Harnett County Government Complex
307 Cornelius Harnett Boulevard
Lillington, NC 27546

October 30, 2007

Re: Status of Improvement Permit Application #07-5-18730

**TRACT TWO
EARL HAILEY, JR.**
DEED BOOK 486, PAGE 195
PIN 9545-32-0803
1.50± ACRES

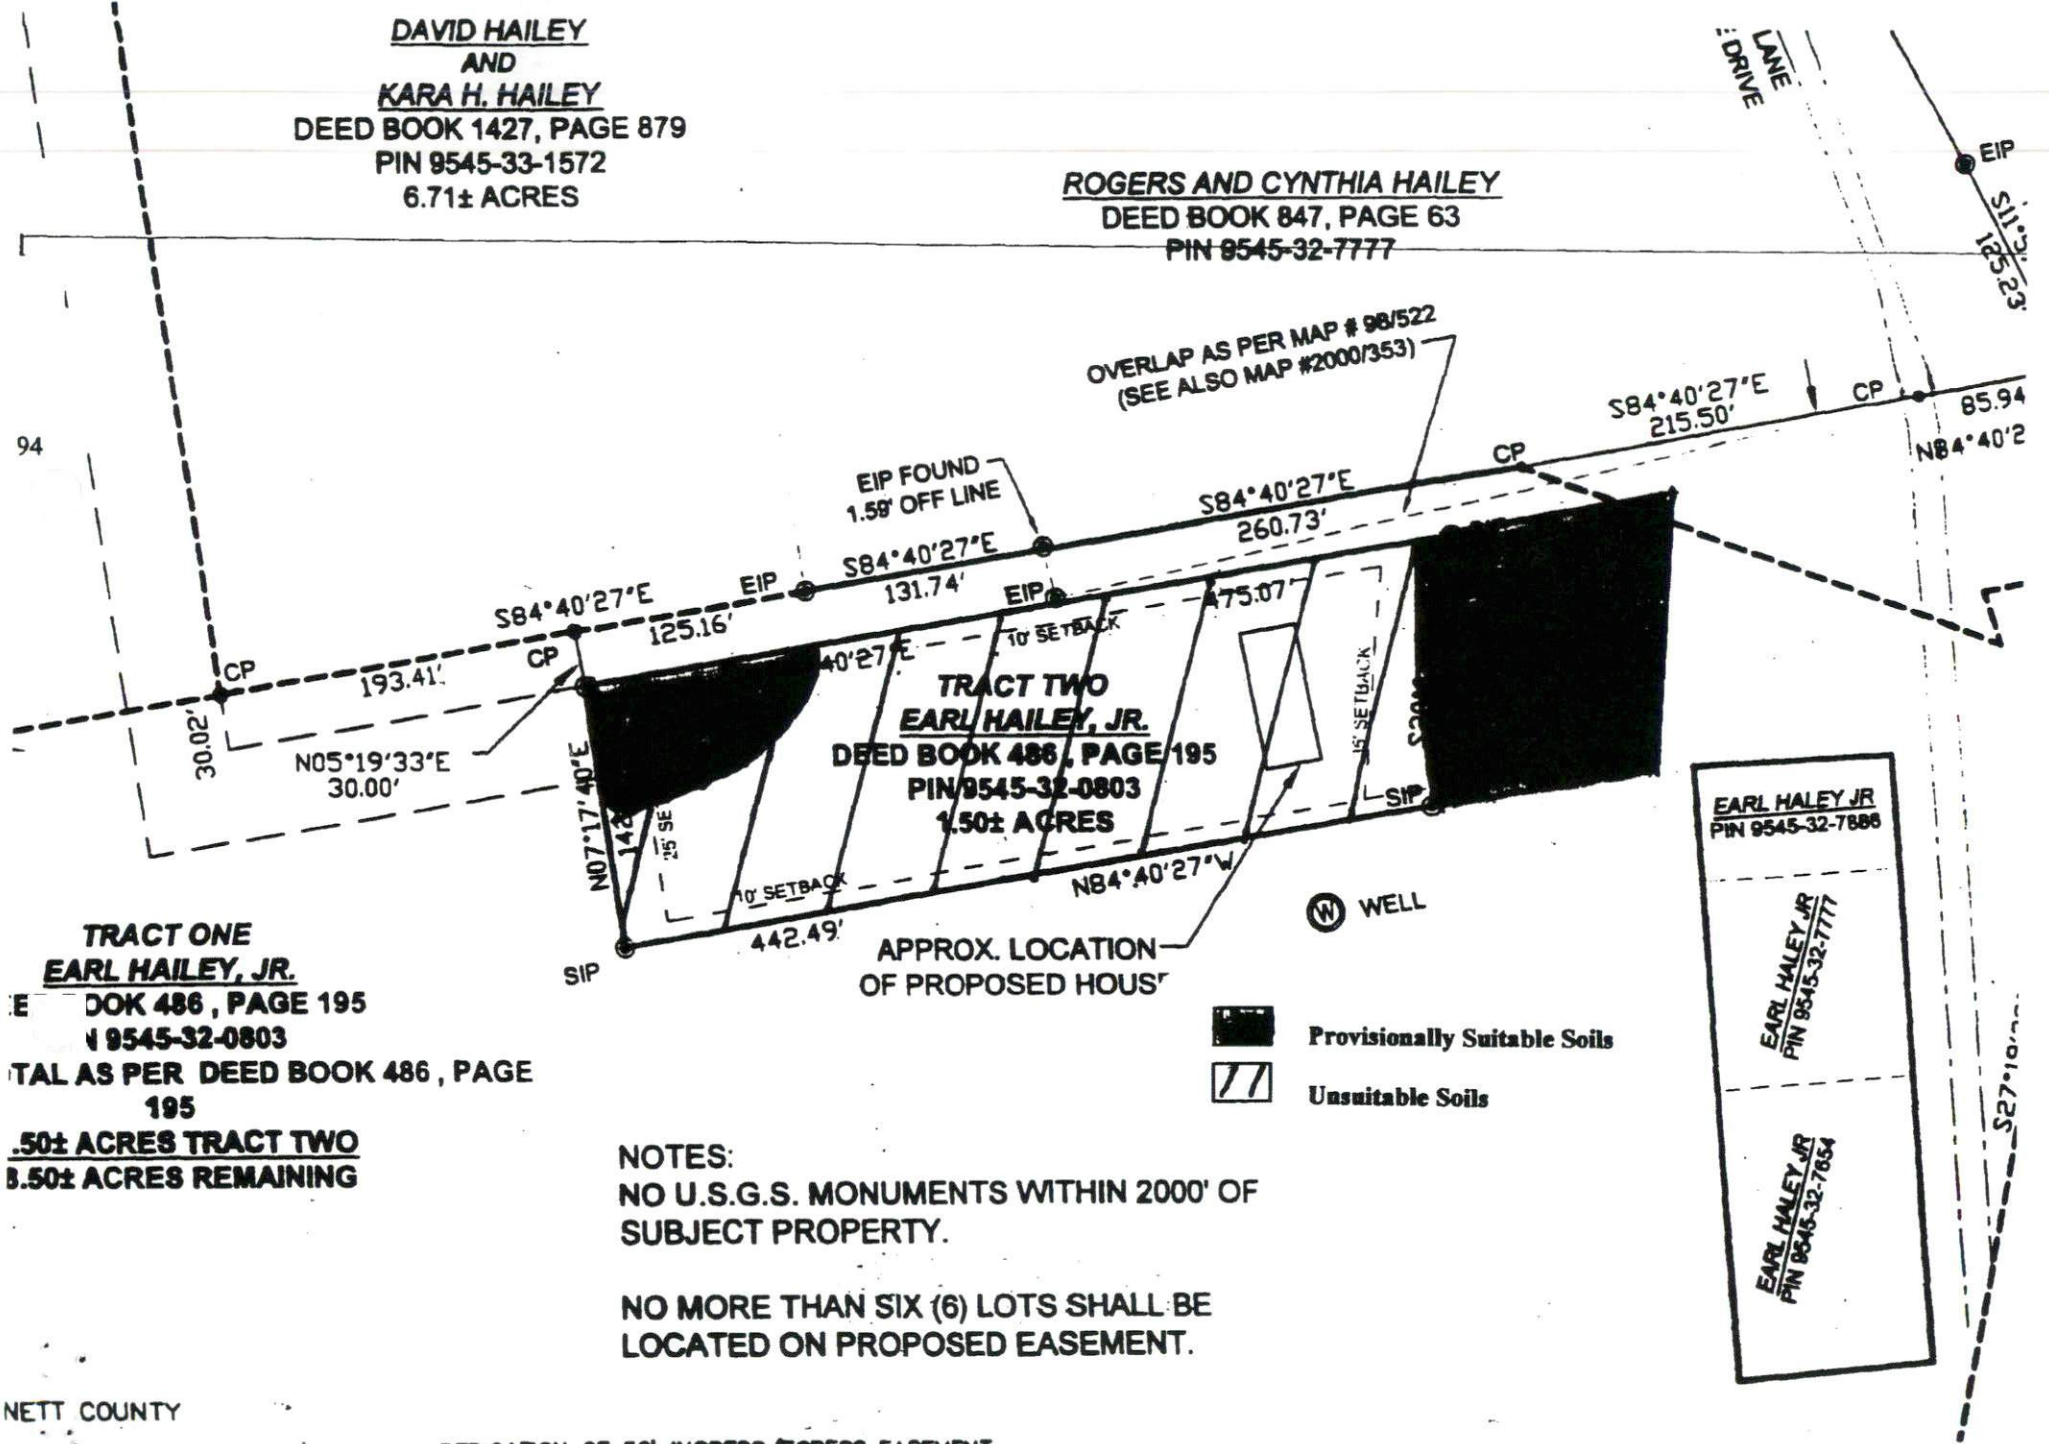
6. Other – Have your surveyor properly mark the septic easement and also I need a recorded copy of the map which shows that the septic easement has been recorded. You will need to submit this as a revision to Central Permitting.
